Planning Application Ref: WA/48/19/RES

Location: Land to the East of Fontwell Avenue, Fontwell Avenue, Fontwell

Description of works: Approval for Reserved Matters following outline permission WA/22/15/OUT comprising 400 new homes (incl. affordable), 360sqm of retail space (A1 to A3), 152sqm of community space (D1 to D2 & including retention & refurbishment of 12sqm 'old smithy'), demolition of remaining buildings to Arundel Road along with public open space, LEAP, MUGA, allotments, car & cycle parking, drainage & associated works - This site also lies within the parish of Barnham & Eastergate

Mark Warwick
Tree Officer / Parks and Greenspace Team

drawing number
6233-T-08

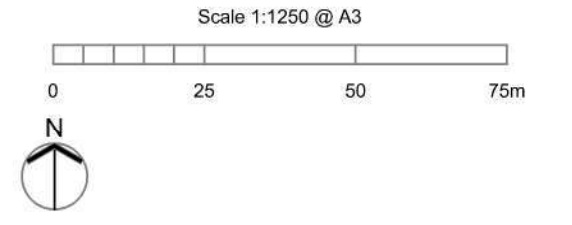
- I recommend **APPROVAL** for this scheme, subject to the following additional condition being applied:
- All activity at the site is to be carried out in strict accordance with: - **Arboricultural Method Statement, FPCR Environment and Design Ltd, May 2019.**
- Before the site is occupied or any machinery is introduced to the site or demolition work or construction work or alterations to existing ground levels takes place a **PRE-COMMENCEMENT Site Meeting** is to take place between the Planning Authority's Tree Officer and the Arboricultural Expert representing the site owner(s) – at this meeting all protective fencing and ground protection measures will be inspected to verify they are 'Fit for Purpose' as required under British Standard 5837:2012 and have been erected and positioned exactly as shown on the approved **Tree Protection Plans dwg. nos. 6233-T-08/-09/-10 Rev A.**

- In order to meet the requirements of condition 11, I recommend we confirm acceptance of the following documents as being the approved scheme for tree protection:
 - **Arboricultural Method Statement, FPCR Environment and Design Ltd, May 2019** (inclusive of Tree Protection Plans, dwg. nos. 6233-T-08/-09/-10 Rev A.
 - **Tree Retention Plan** (Detailed Access Junction), dwg. no. **6233-A-08 Rev C.**
